**DE-2018/215**

4 July 2019

## **STATE SIGNIFICANT DEVELOPMENT – KEMBLA GRANGE RESOURCE RECOVERY FACILITY (SSD 5300 MOD 2) – COMMENTS ON RESPONSE TO SUBMISSIONS**

Drawing Title PROPOSED INDUSTRIAL DEVELOPMENT LOT 10 DP 878167 WYLLIE ROAD, KEMBLA GRANGE TURNING SWEEP PATHS	Project No. KF110816
Scale 1:500 @ A1 1:1000 @ A3	Drawing Status ISSUED FOR SSD5300 MOD2 CC

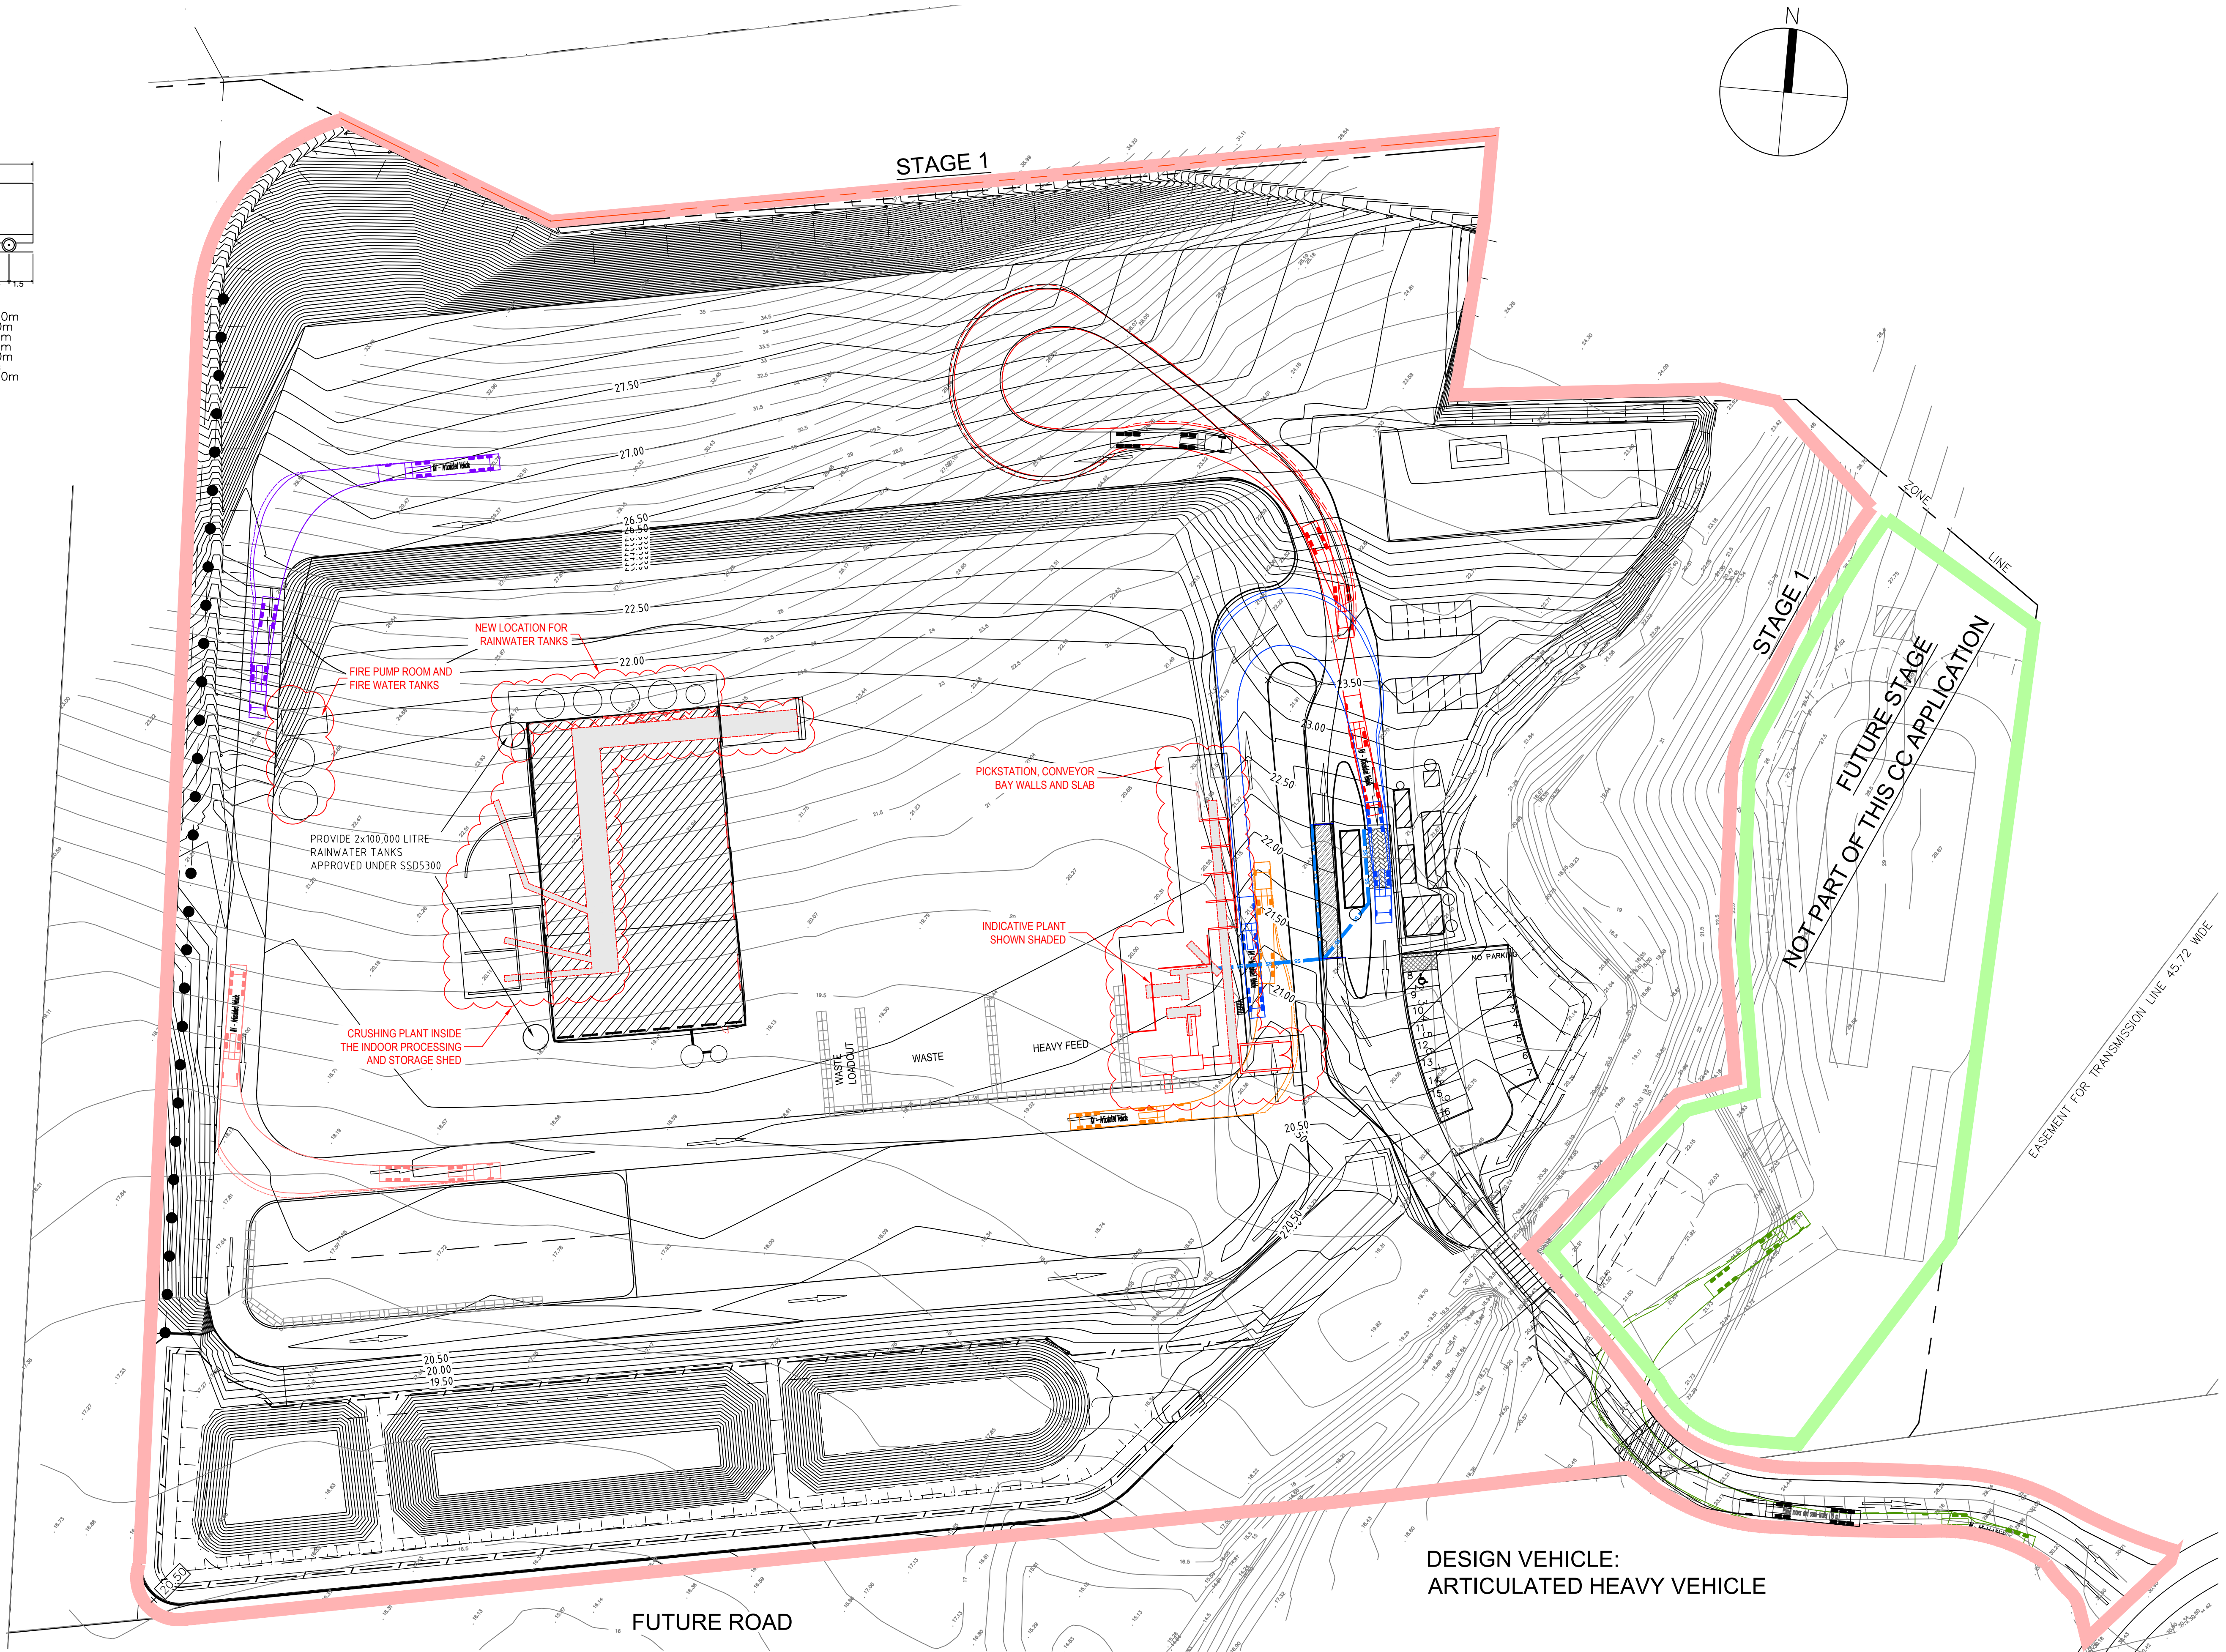
- The 'Blown Material Cage' appears to interact with the turning movements and site access arrangement for the site. The turn path provided on Drawing C305 Job no. KF110816, Revision D, dated 09/10/2018 utilises a Heavy Rigid Vehicle at the location adjacent to the 'Blown Material Cage' when the design vehicle for the rest of the site is an Articulated Vehicle.
